Friends of Carrington Moss (20048873) Response to ExQ1 Submission to Deadline 3: Tuesday 5 November 2024.

## Environmental Statement Figures Chapter 14 Climate

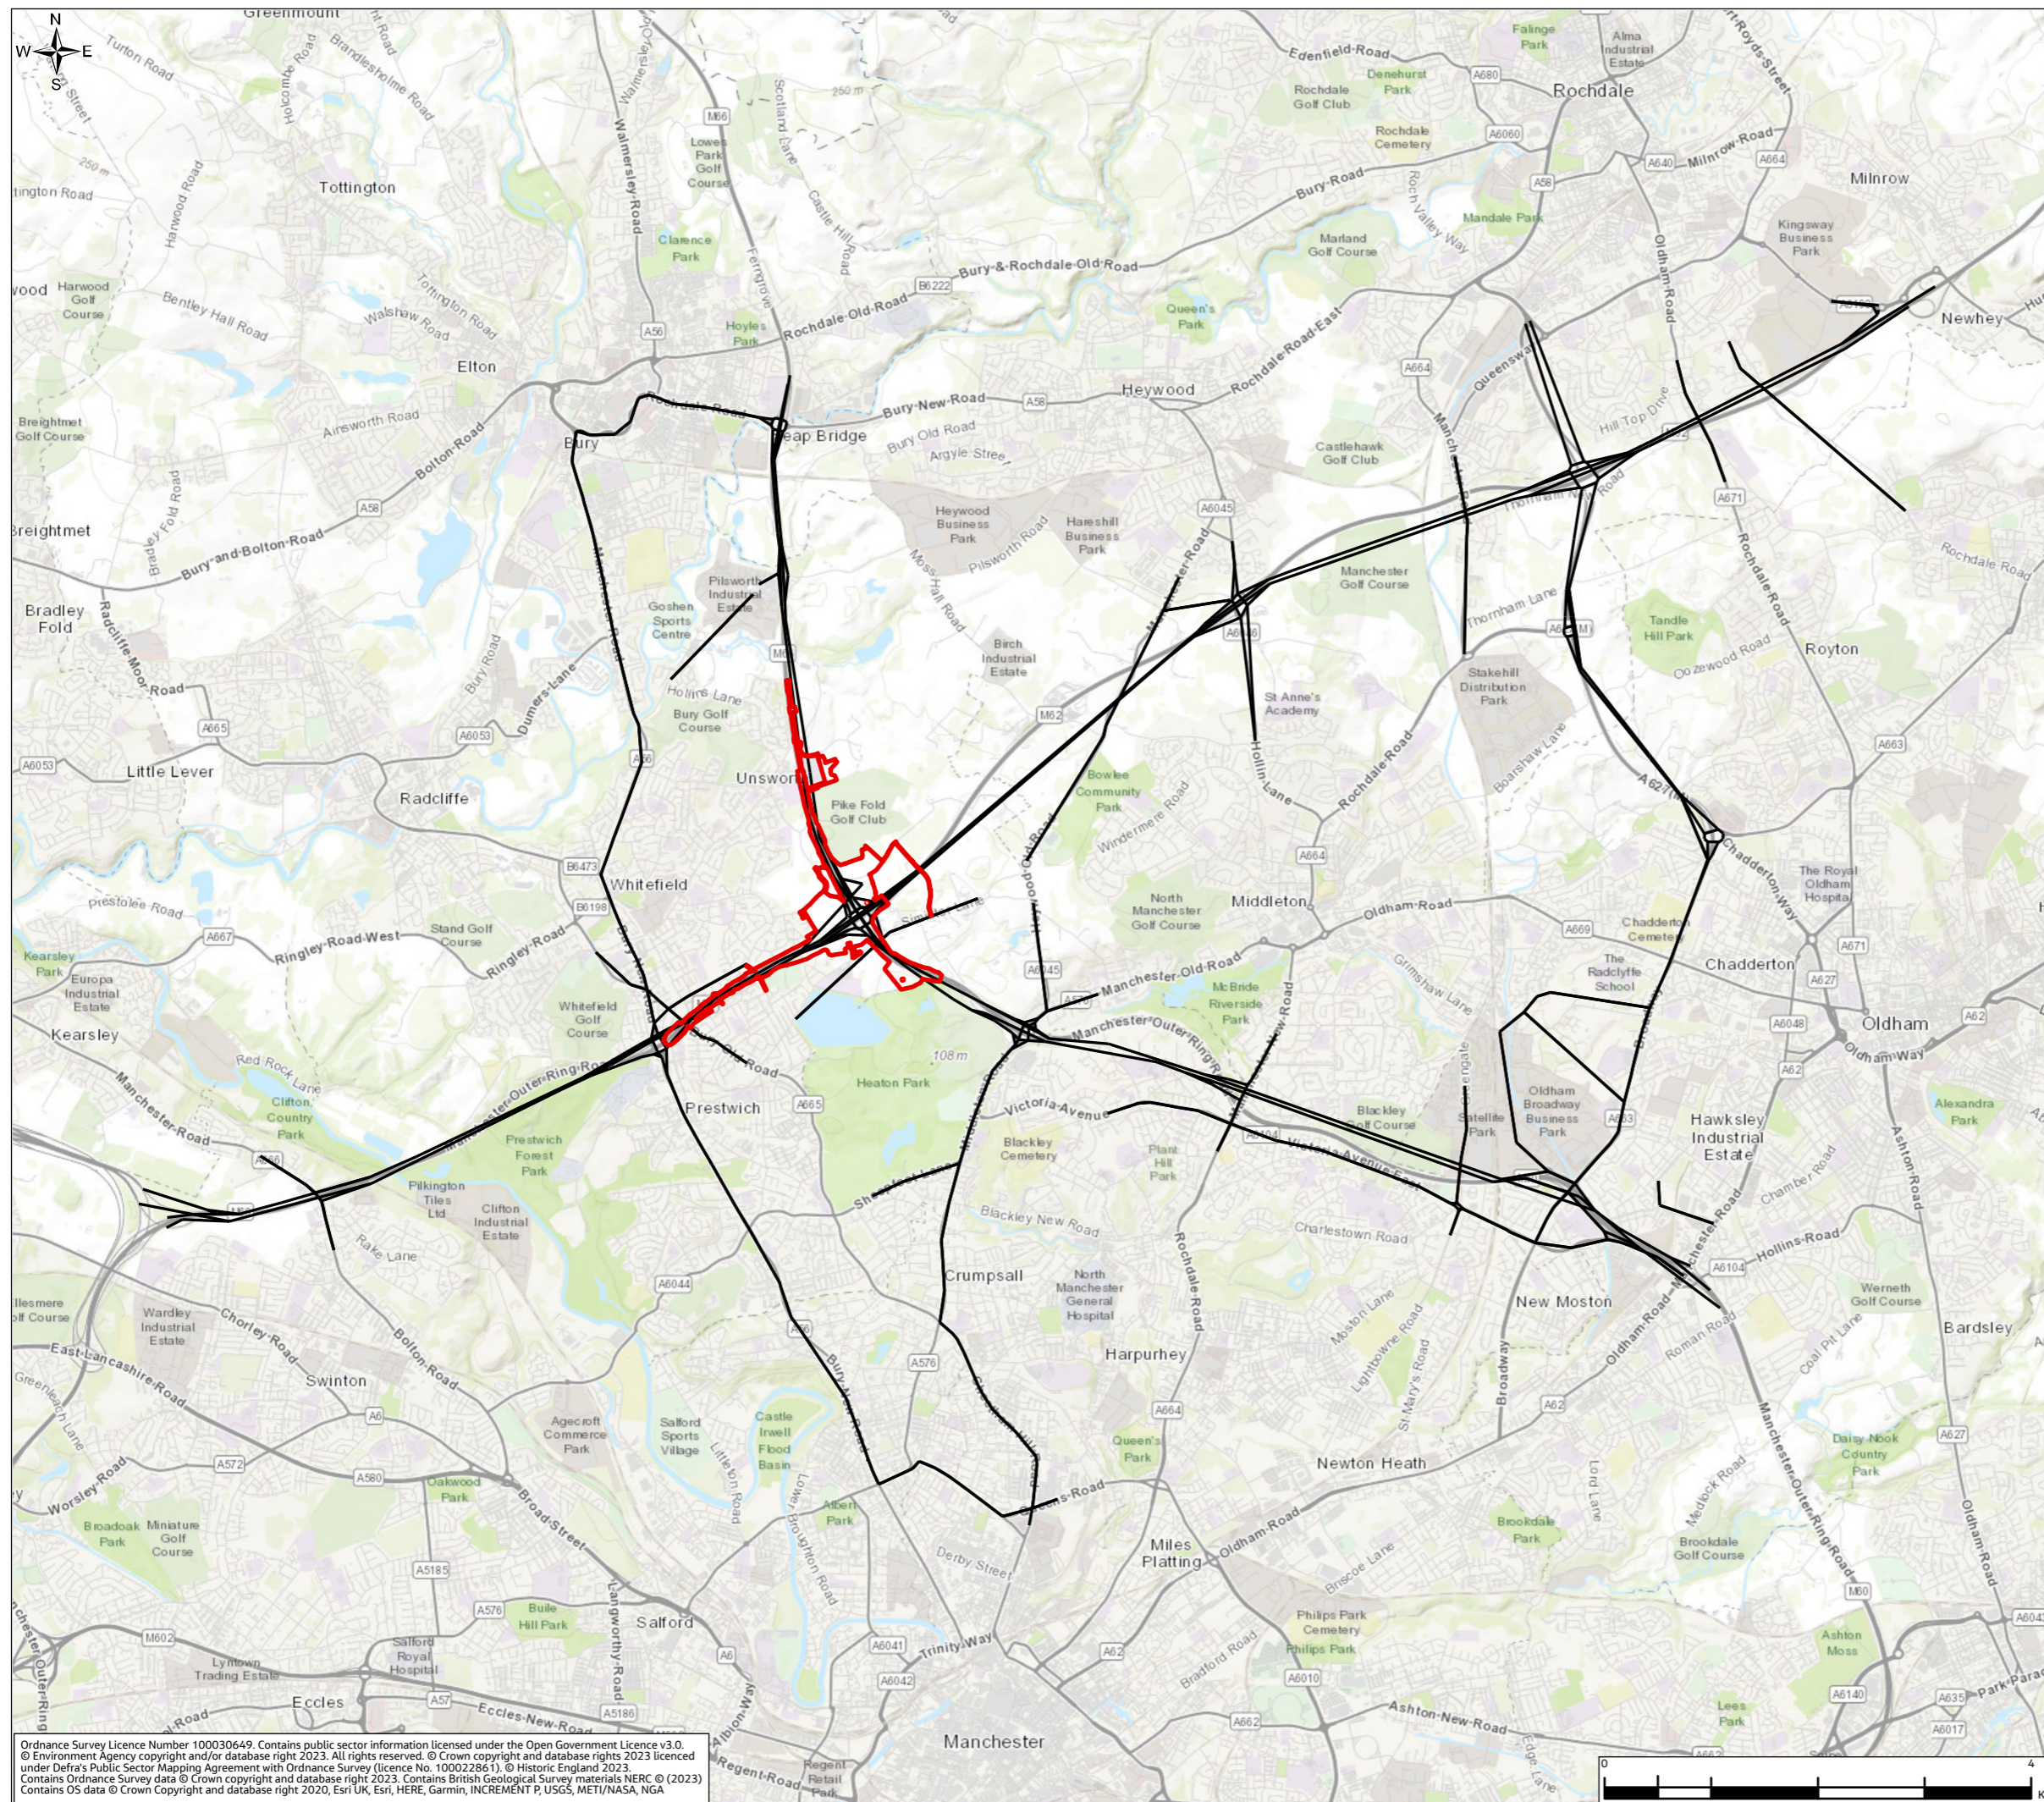
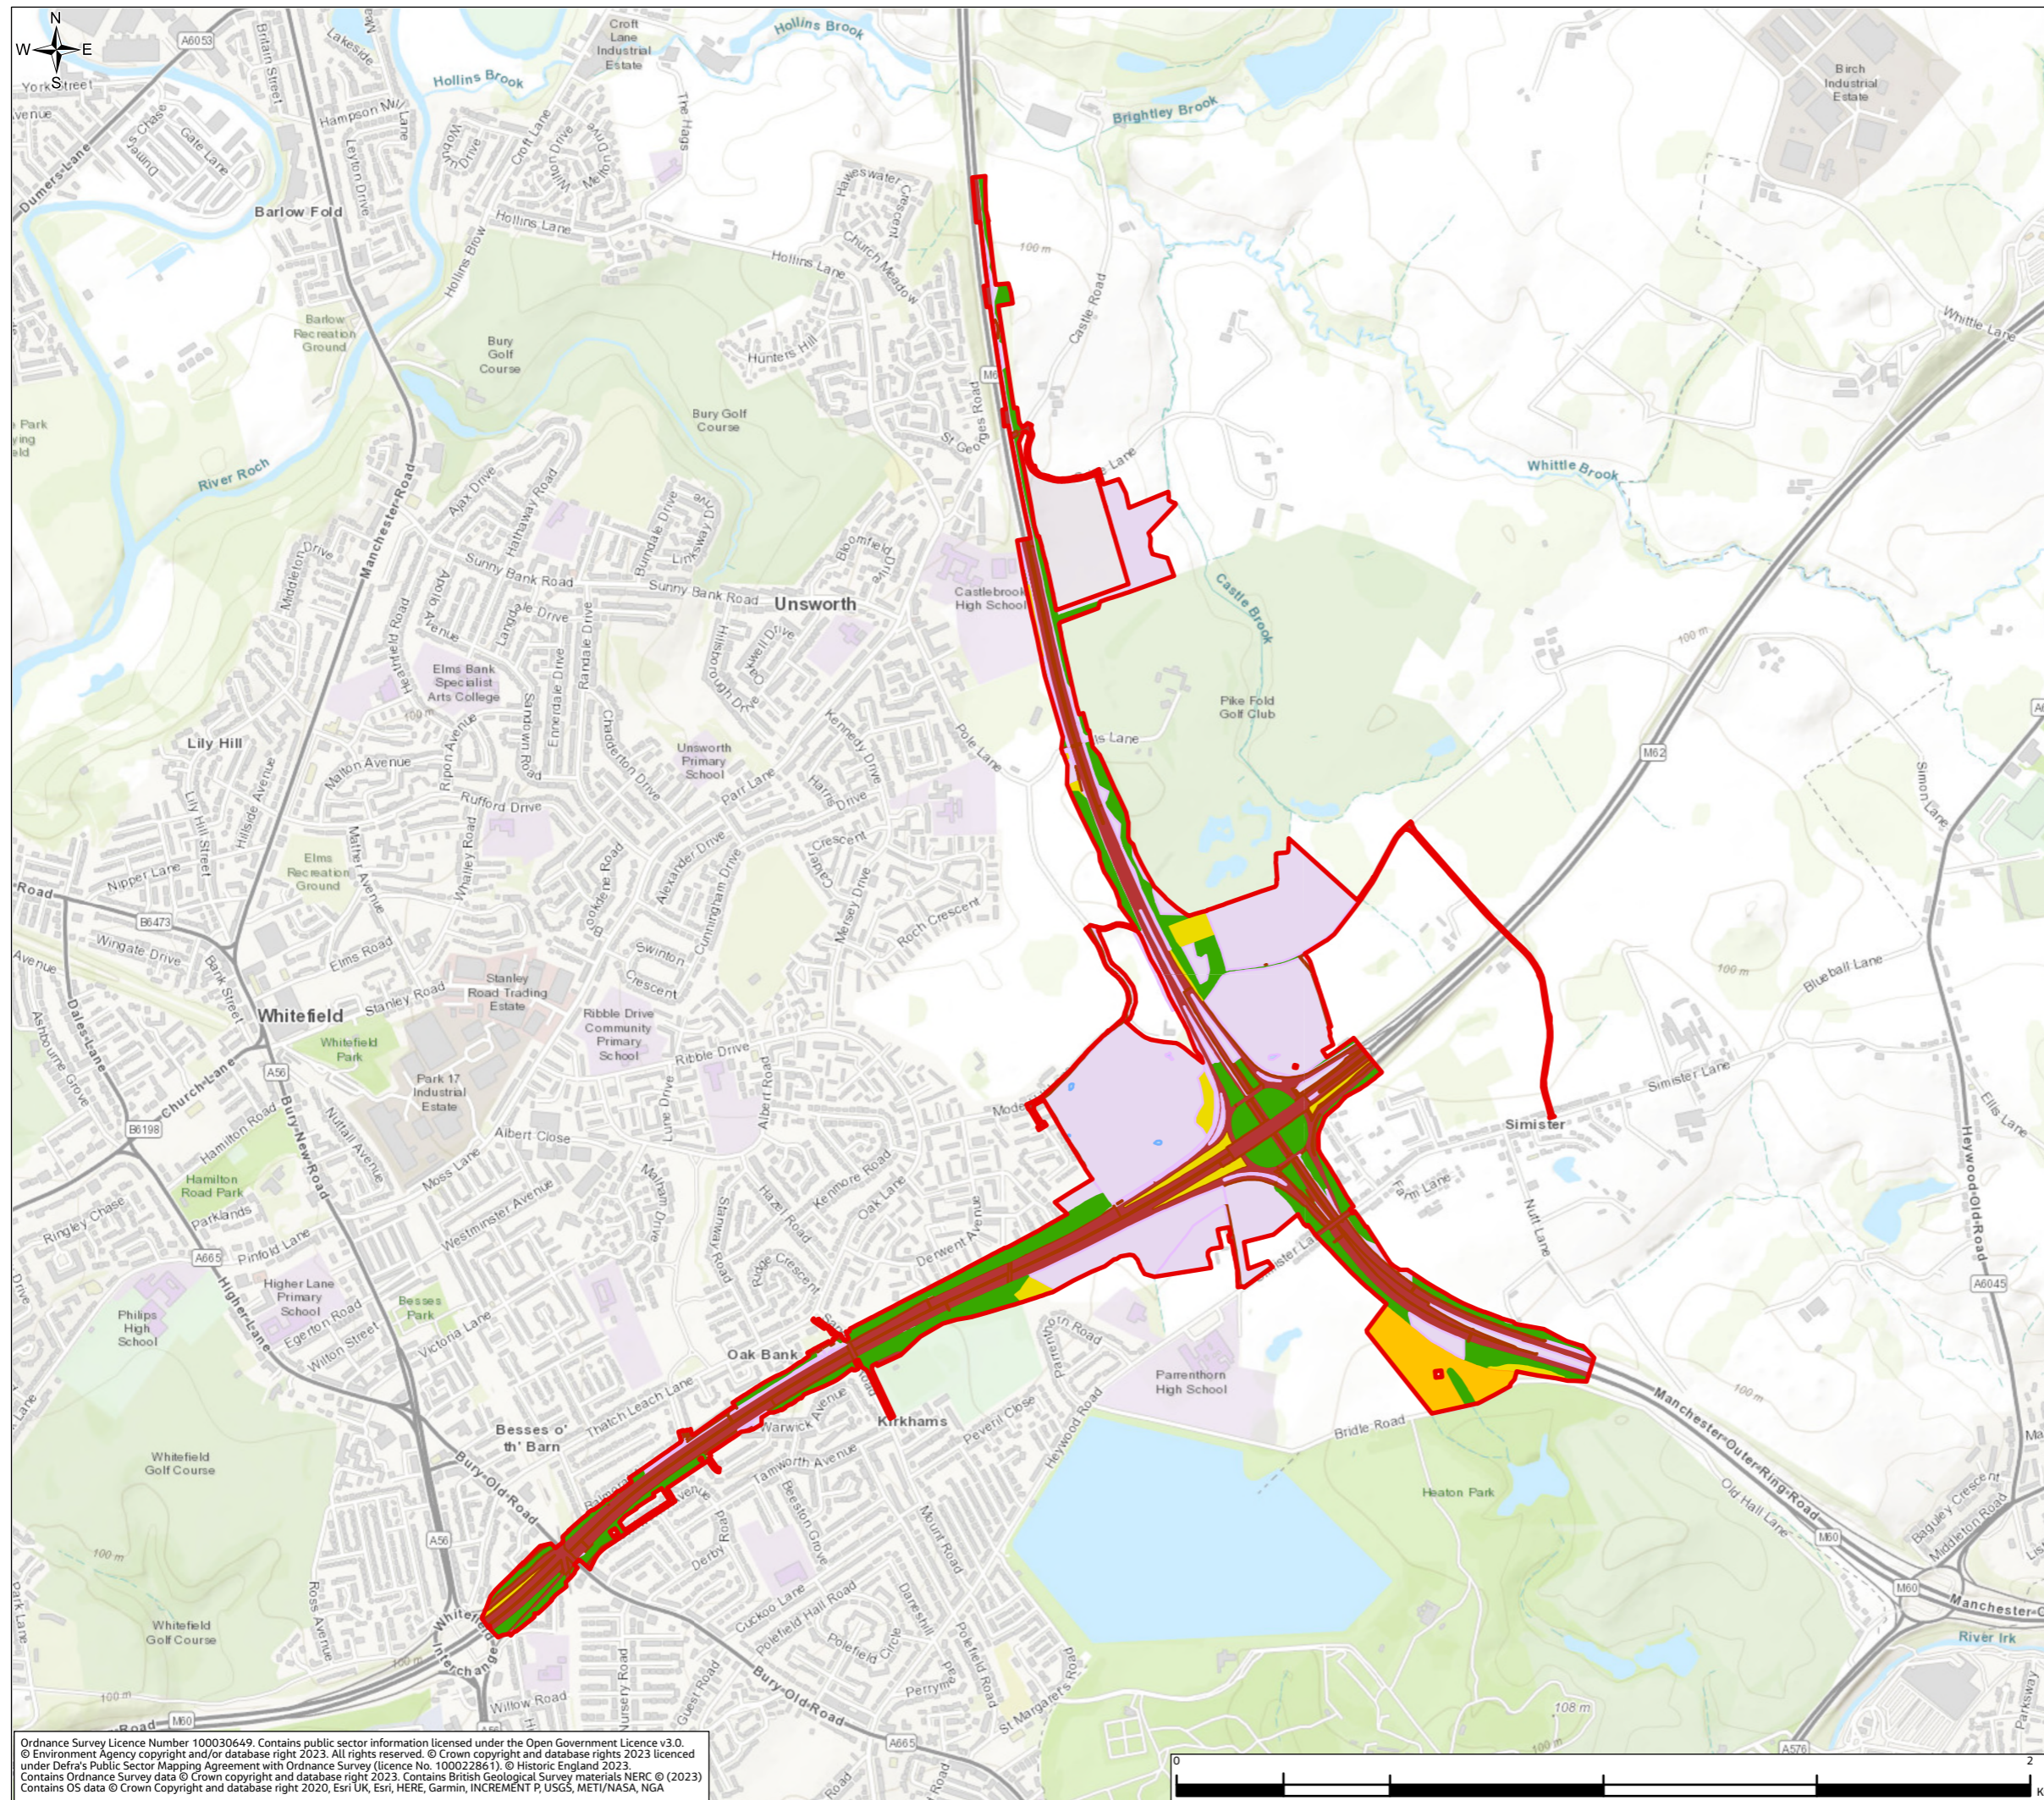
It is challenging to determine whether we agree with the methodology and assessment findings set out in ES Chapter 14 because we just have summary figures, the detailed calculations are not revealed. So, whilst we can assume it is a competent piece of work, we do question some of the assumptions made:

- The assessment confirms that the scheme will lead to an increase in carbon emissions, of some 62 kTonnes. The assessors argue that this is miniscule against the UK carbon budget. This is poor reasoning because, whilst it is numerically correct, it does not consider the cumulative impact of all such developments in relation to achievement of the national target. If every development nationwide produces a small increase in carbon emissions, how can net zero be achieved?

For a more local comparison, the figure represents circa 0.09% of the 67 Megatonnes in Greater Manchester's carbon budget, which the monitoring reports suggest is already being seriously exceeded (see page 18 of the latest progress report⁸ "*The latest data show GM emitted 11.2Mt of CO₂ in 2021, an increase (worsening) from the previous report at 10.7Mt of CO₂*" and the emissions dashboard⁹, for which the latest data shows that GM is over the carbon budget by 21.3 MtCO₂).

- It does not appear that any allowance has been made for the opportunity cost of lost carbon sequestration as a consequence of land sealing.
- It is unclear whether carbon emissions from the anticipated induced traffic have been included within the calculations. This is particularly important given the significant level of development proposed in the now adopted Places for Everyone Plan. Given the lack of sustainable passenger (rail/tram) and freight (rail/water) transport proposed in that Plan, the carbon emissions associated with the consequential huge increases in traffic should be taken into consideration.

- Whilst the assessment highlights the quantitative analysis that has been undertaken, there needs to be more qualitative analysis to ensure the scheme is compliant with national, regional and local policies designed to reduce cumulative emissions.
